From: Bloomer, David [David.Bloomer@lancashire.gov.uk]**Sent:** 15 February 2013 14:34**To:** Graeme Thorpe**Subject:** RE: app/2012/1077 The Longridge Restaurant

The revised layout for the parking is acceptable, whilst there is a shortfall in parking provision my preference would be for the additional parking to be on street rather than using the short spaces originally proposed which would lead to the possibility that the footway would be obstructed. In respect of conditions, I would request that the following condition be attached to any permission that may be granted.

**Proposed
Site Plan**

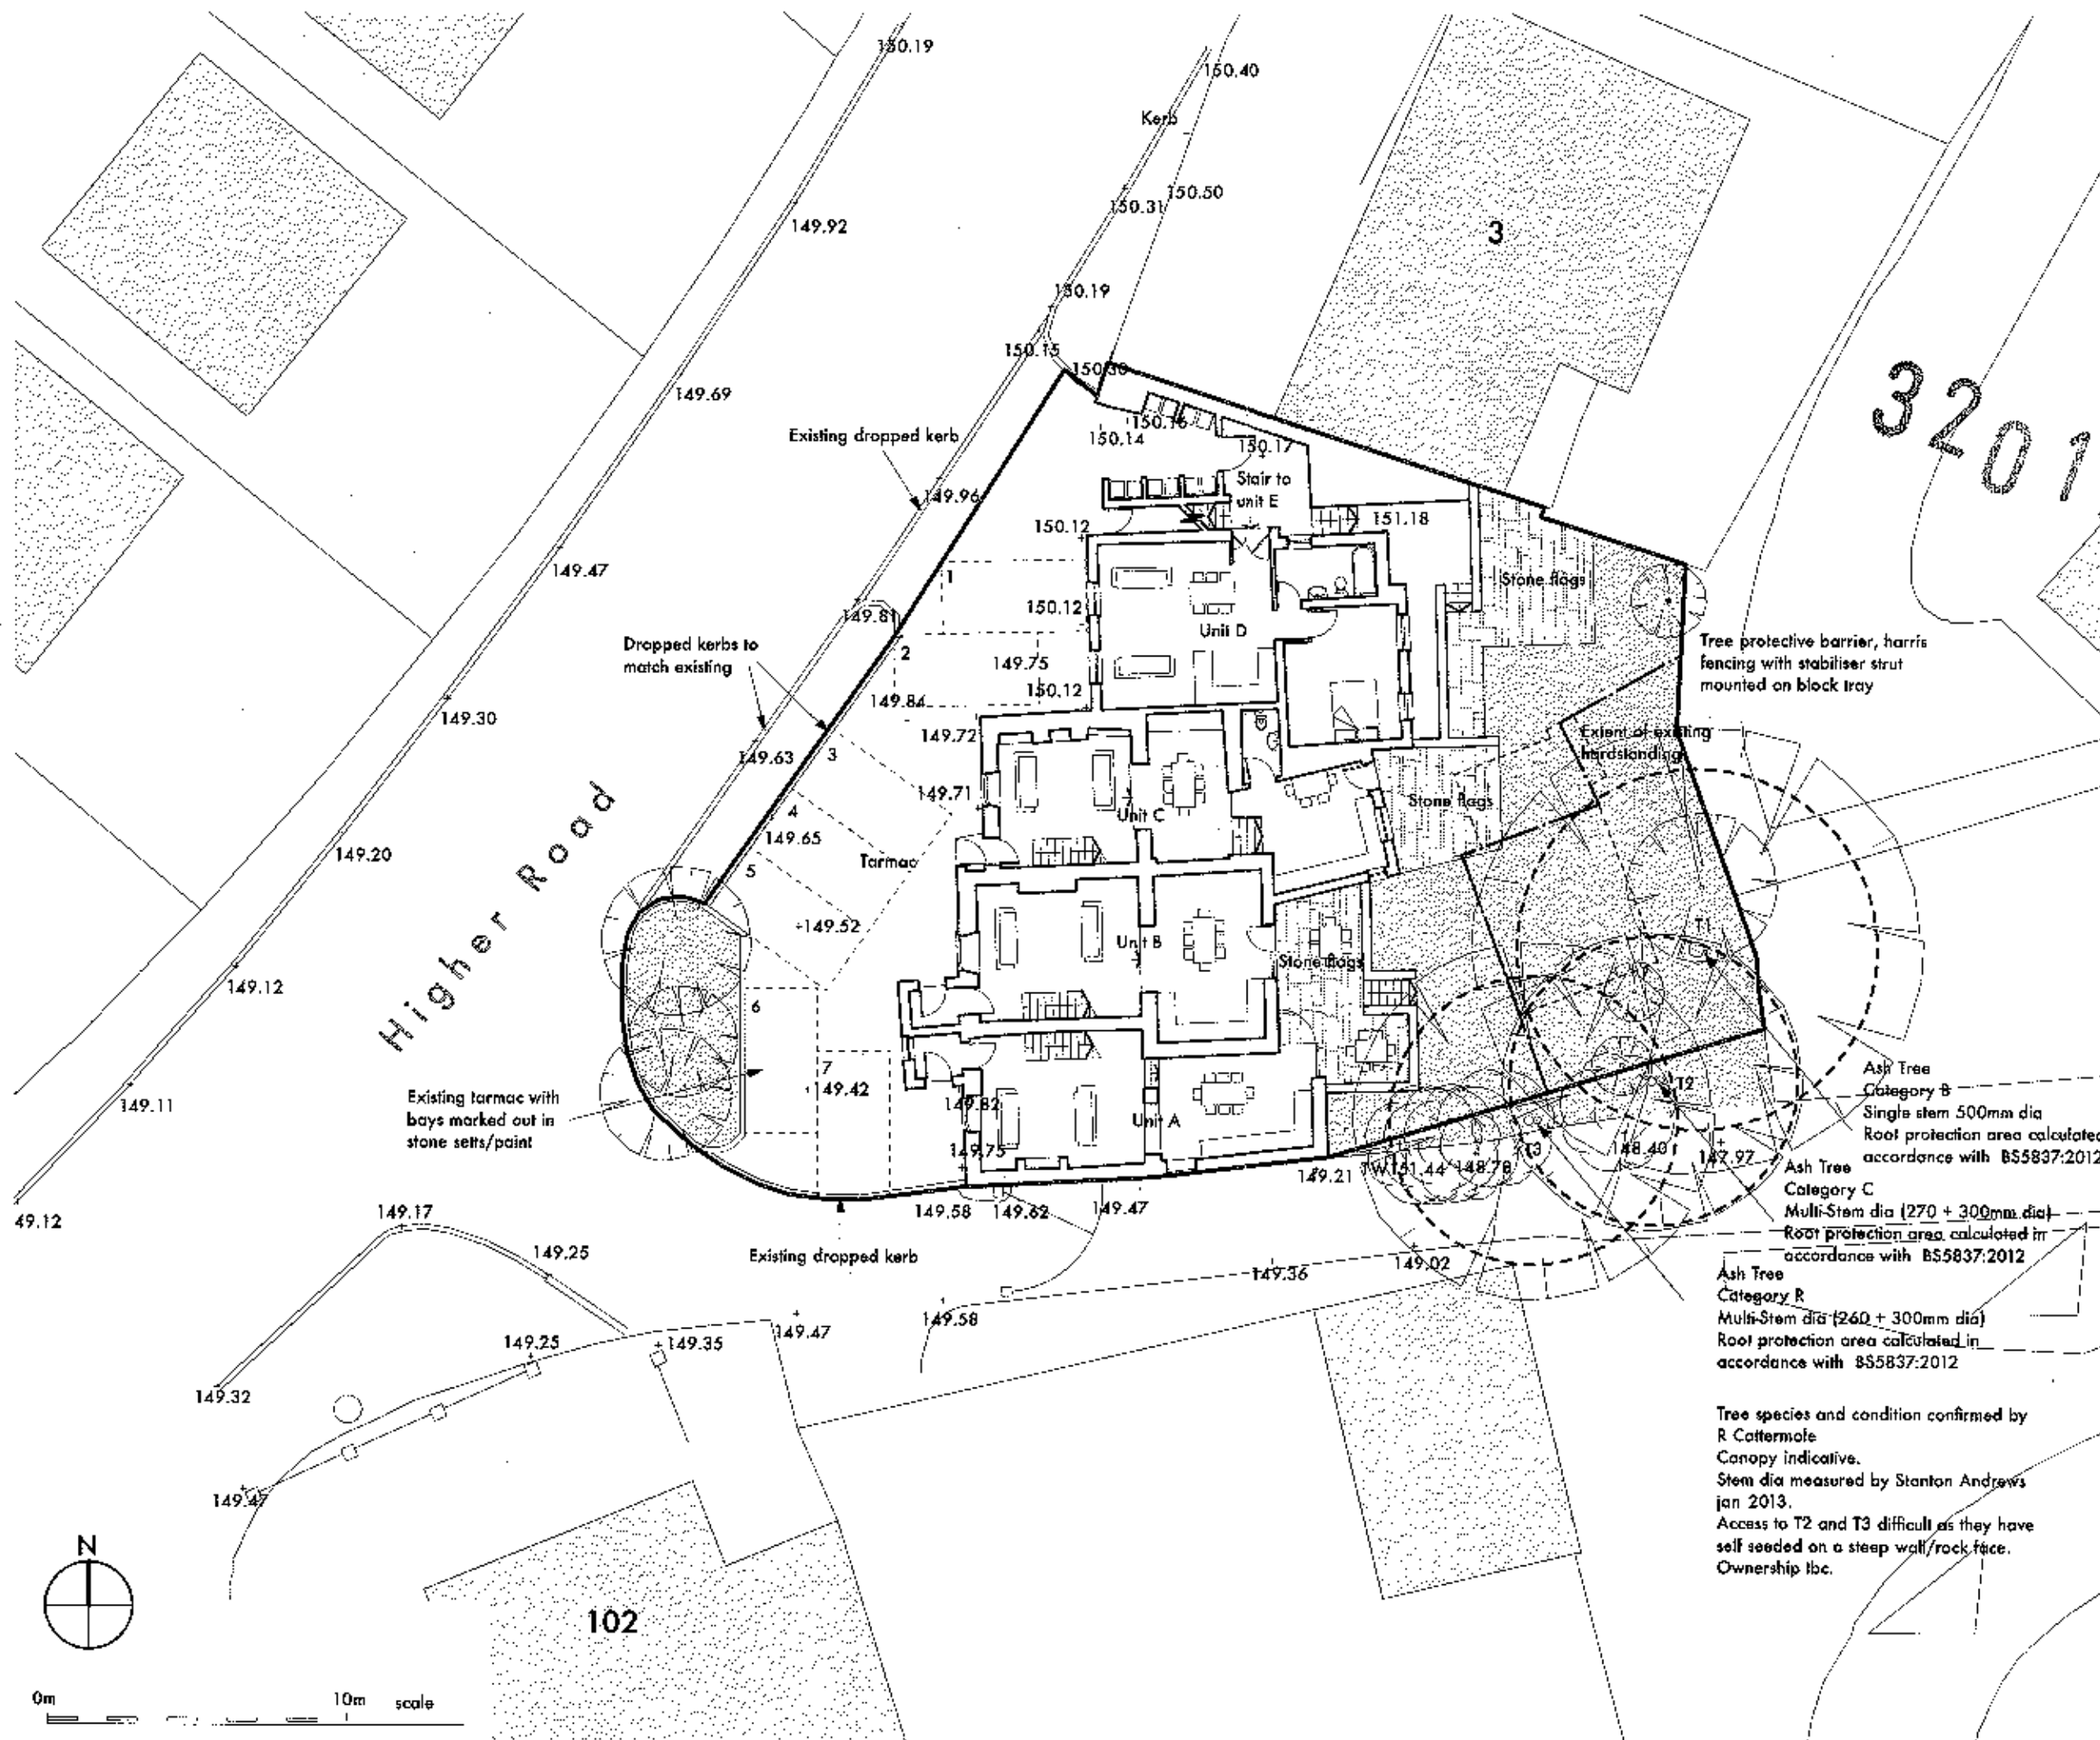
Thanks for the plan. The revised parking layout does remove the likelihood of vehicles encroaching over the footway and I would therefore consider it acceptable. It will be necessary to amend the footway construction at various locations along the Higher Road frontage to ensure that only the identified parking spaces are accessible. This will be recommended for attachment to any subsequent planning permission that may be granted.

Prior to commencing work on site the applicant shall submit , for approval by the planning Authority in consultation with the Highway Authority , a plan showing the proposed amendments to the footway adjacent to the site showing where footway crossings are to be provided and where the footway is to be reinstated. The Footway reinstatement shall be in accordance with the County Council's Specification for the Construction of Estate Roads and shall be completed prior to the occupation of the residential units. Reason, to limit the number and location of the access points and to maintain the proper construction of the footway.
